Cabarita Mixed Use Development-6 (MP07_0179-Mod-6)
Request for Response to Submissions

ATTACHMENT 1

DEPARTMENT OF PLANNING, INDUSTRY AND ENVIRONMENT

TWEED COAST ROAD ELEVATION
AMENDED APPROVAL COMPARISON

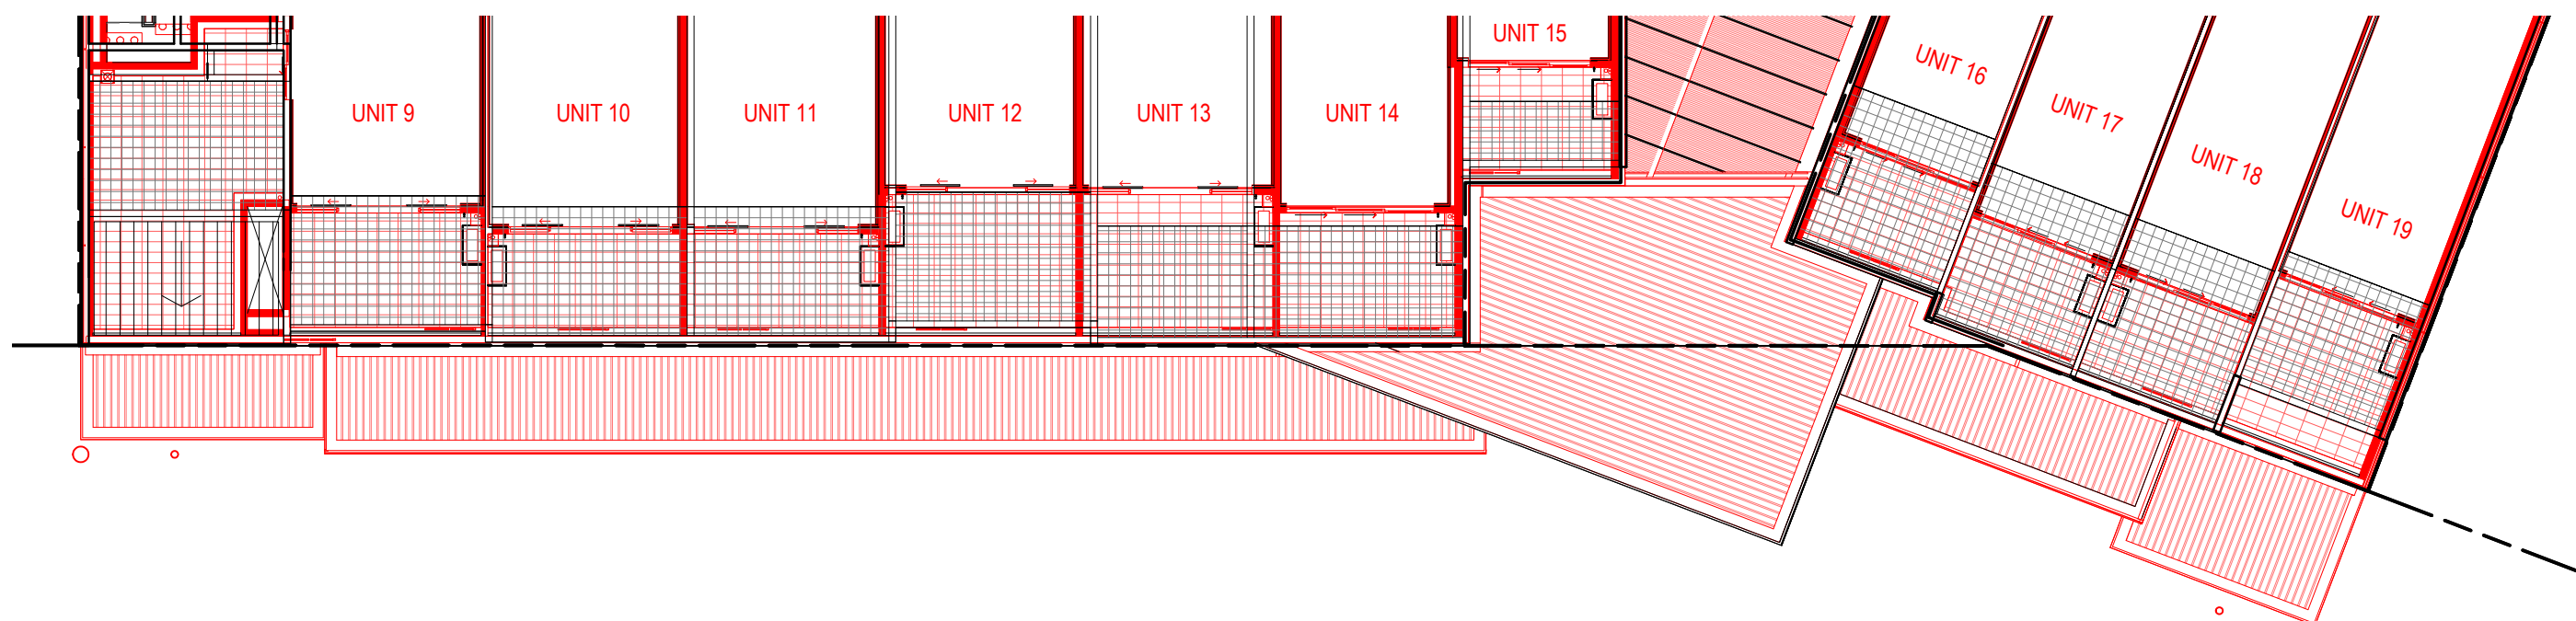
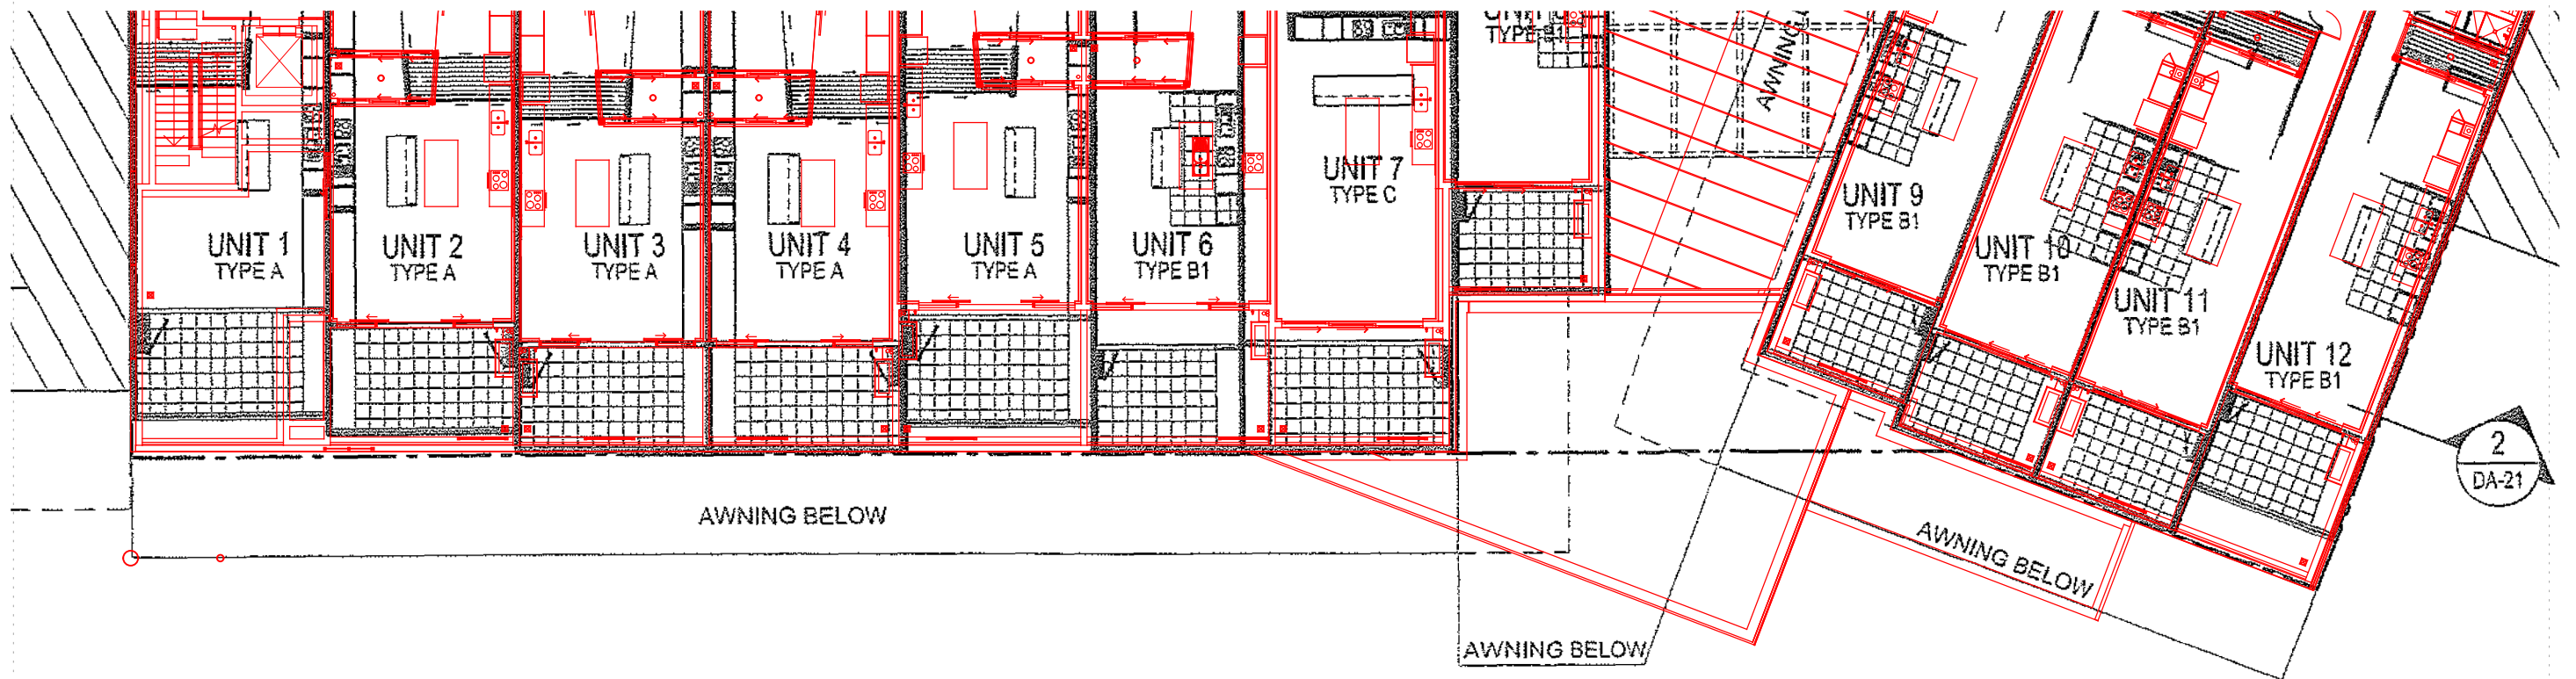
- There appear to be a number of changes proposed to the Tweed Coast Road elevation. It seems the balconies of these units have been reduced in depth by up to 1 metre (m), compromising their functionality and reducing residential amenity. Stepping in the balconies across the units has also been deleted, and the south eastern corner which was previously recessed has now been filled with a balcony area both of which reduce articulation of the façade.

The submitted modification report indicates that to satisfy conditions B3 and B4, the units facing Hastings Road were shifted to the west. There is no discussion of these apparent changes to the Tweed Coast Road façade. Please explain the reasoning for these changes and address both the amenity impacts for the residents, and the visual impacts arising from this change.

drawing title
LEVEL 1 FLOOR PLAN

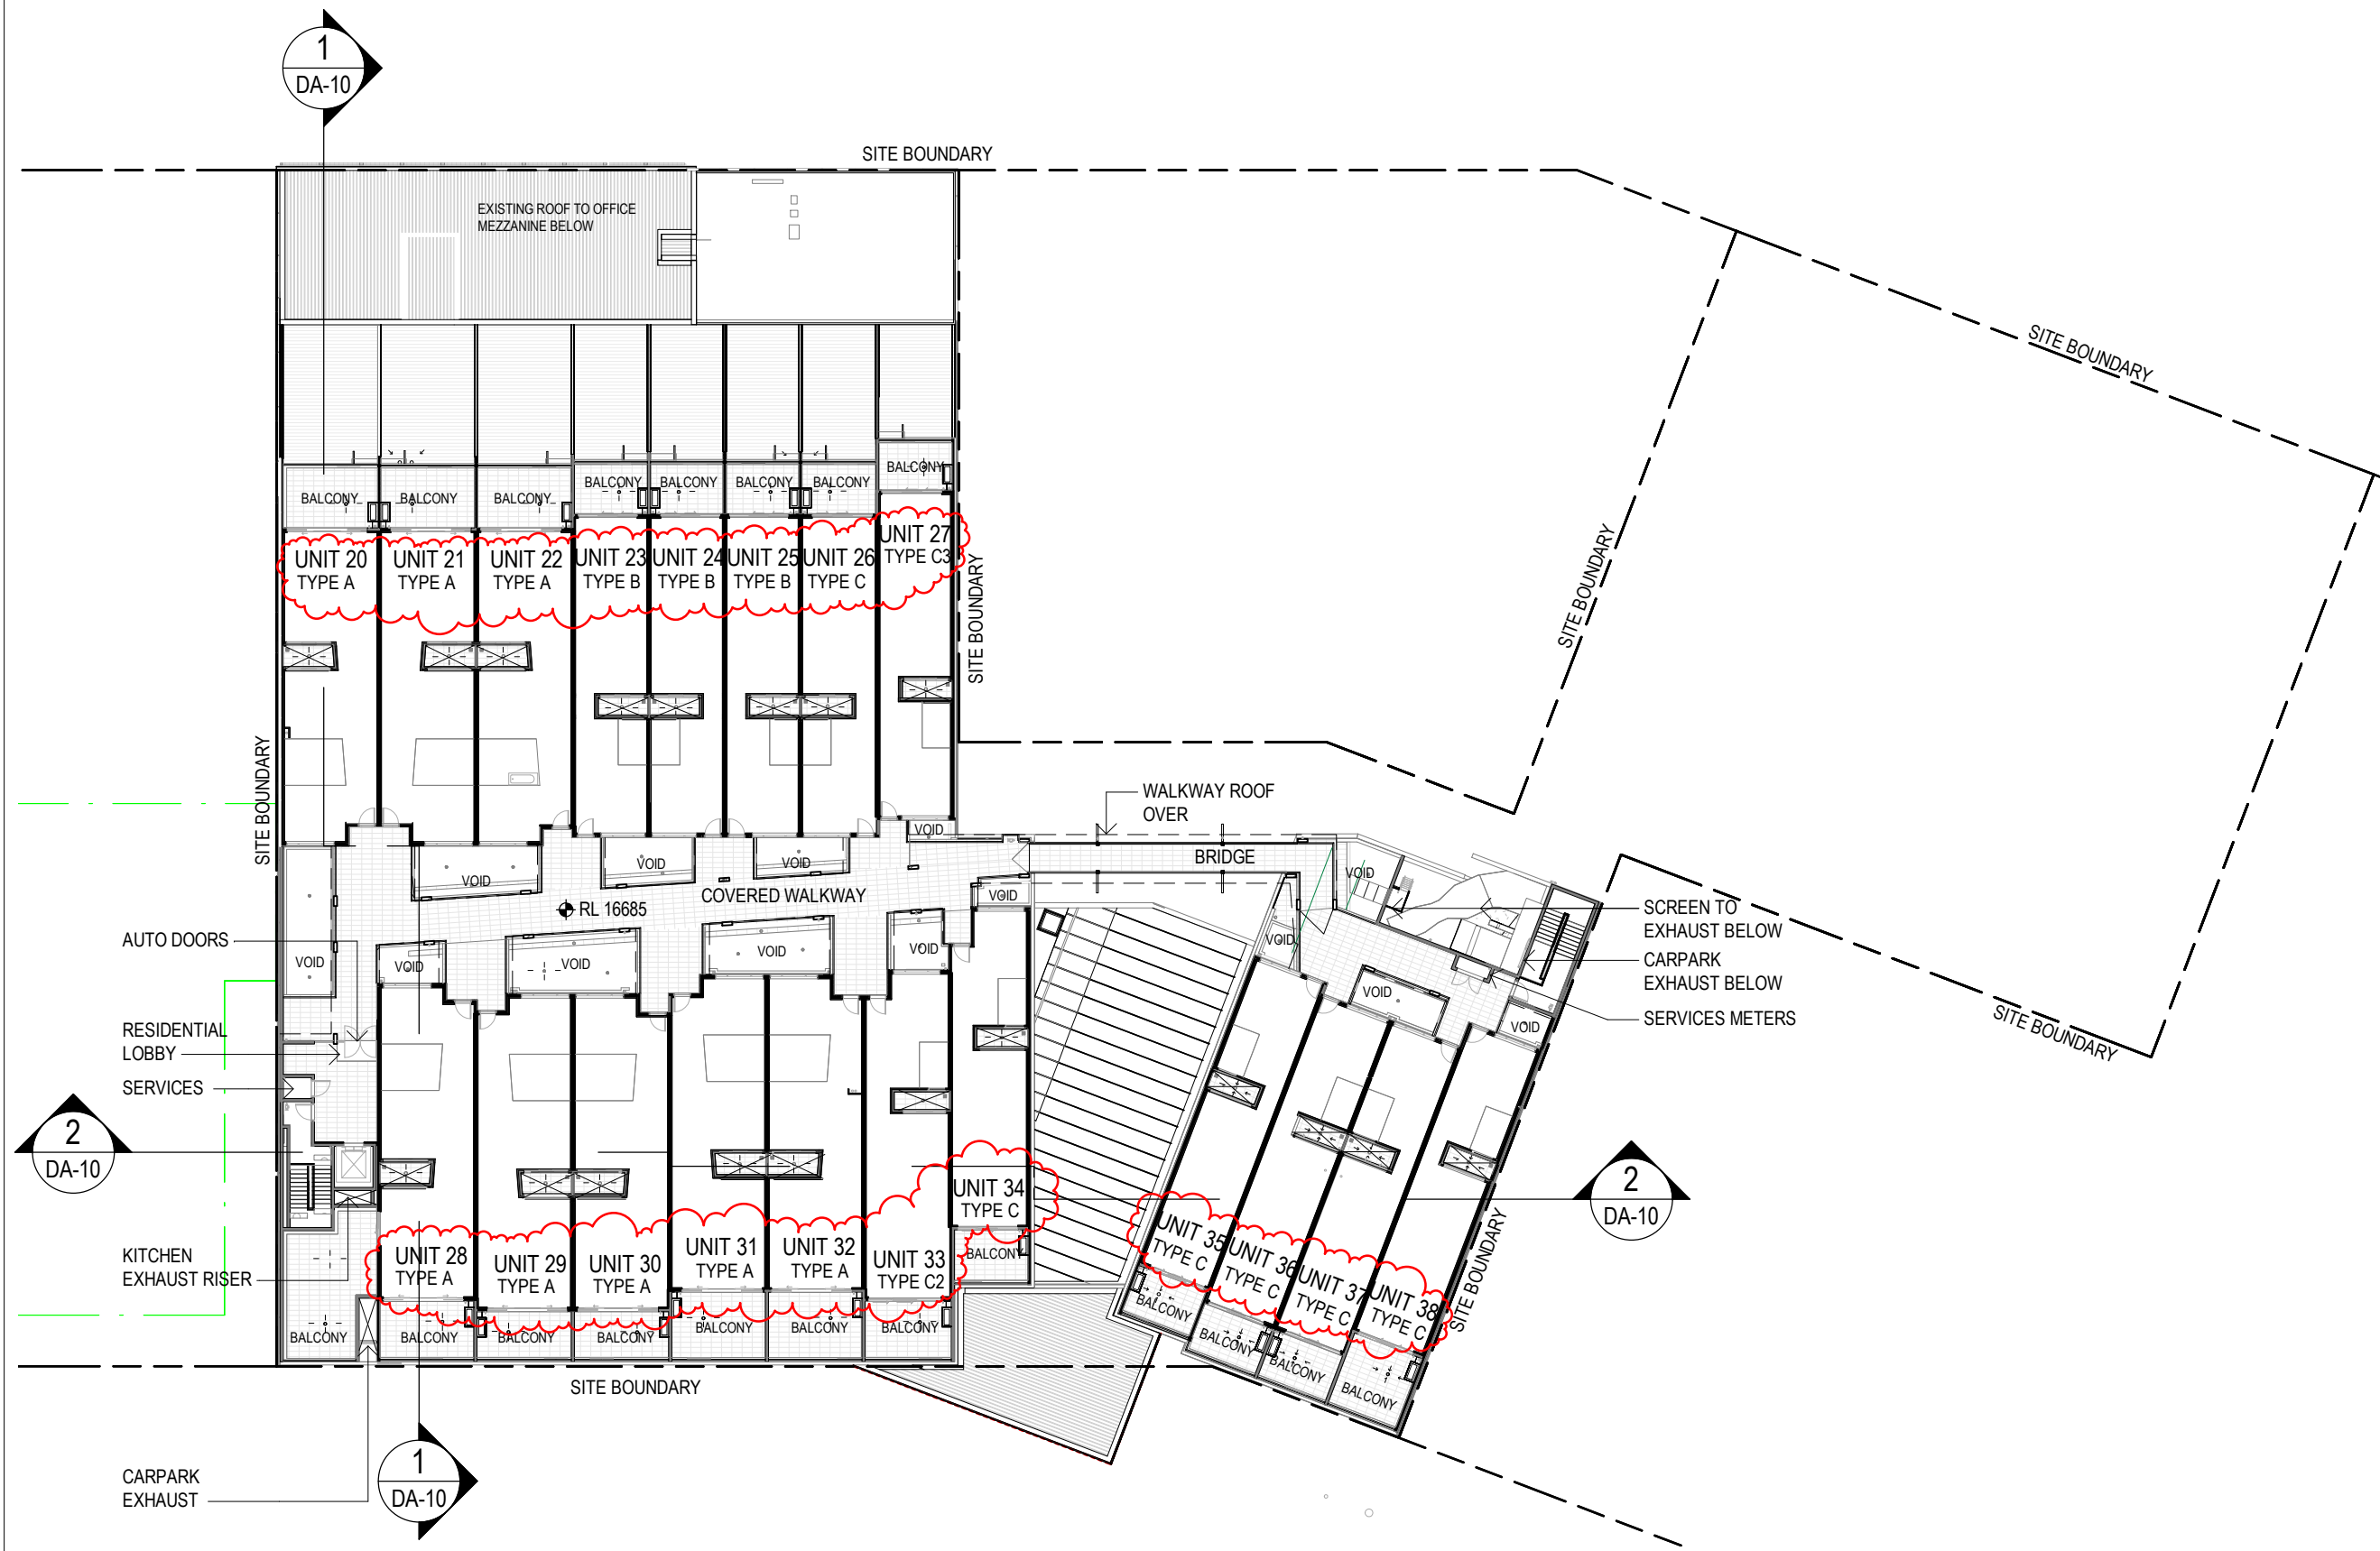
- The Department understands that the modification includes the reallocation of the Level 1 landscaped podium to eight individual courtyards accessible by Units 1-8. In the approved plans, this landscaped podium was intended to function as a landscaped buffer between the units and the surrounding properties in terms of visual amenity, noise and privacy in line with the objectives and design guidance of SEPP 65.

The impacts of the change of this space from a mostly inaccessible, landscaped open space to private balconies have not been adequately addressed for the surrounding properties, having only considered internal impacts in the submitted SEE. Please provide an adequate assessment of the impacts of this change on neighbouring properties, specifically on Hastings Road and the properties opposite.

The Department recommends reconsidering the design to provide open space, potentially remaining accessible by Units 1-8 to be used primarily as a passive communal area, with potential for west orientated seating and walkways connecting seating areas, in line with the objectives and design guidance of SEPP 65 and the Apartment Design Guide.
